REF: N208370

DATE: 10 March 2021

**RE: EASTERN CREEK RETAIL OUTLET CENTRE (SSD-10457) – TRAFFIC PEER REVIEW**

Further to your request, GTA Consultants (GTA), now Stantec, has undertaken a peer review of a traffic and transport report<sup>1</sup> (herein referred to as “The CBRK study”) prepared by Colston Budd Rogers and Kafes (CBRK) for the State significant development (SSD-10457) comprising a new retail outlet centre at Lot 3 of the Eastern Creek Quarter site located in the Western Sydney Parklands.

**Base case weekday afternoon
peak hour traffic flows plus
development traffic
Figure 2**

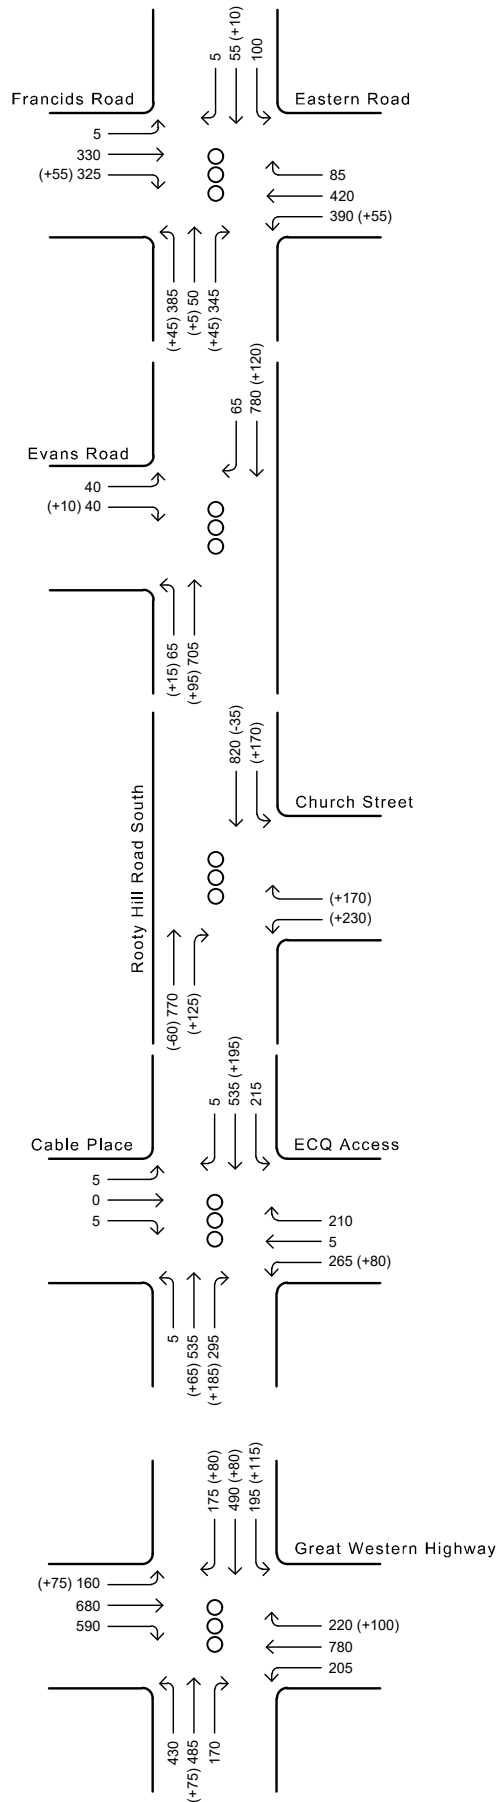
It is further noted that an extrapolation of the traffic volumes presented in Figure 2 in the CBRK study indicates that the Lot 2 is expected to generate some 487 vehicle trips in the afternoon peak period (i.e., 757 vehicle trips less 270 vehicle trips expected to be generated by Lot 1). For the Lot 1 floor area of 10,428 square metres, this generation equates to an existing rate of approximately 4.7 vehicle trips per 100m<sup>2</sup> GFA. This existing rate is discussed further below as it is noted that a significantly lower traffic generation rate is assumed in the CBRK report for the new floor area in Lot 3.
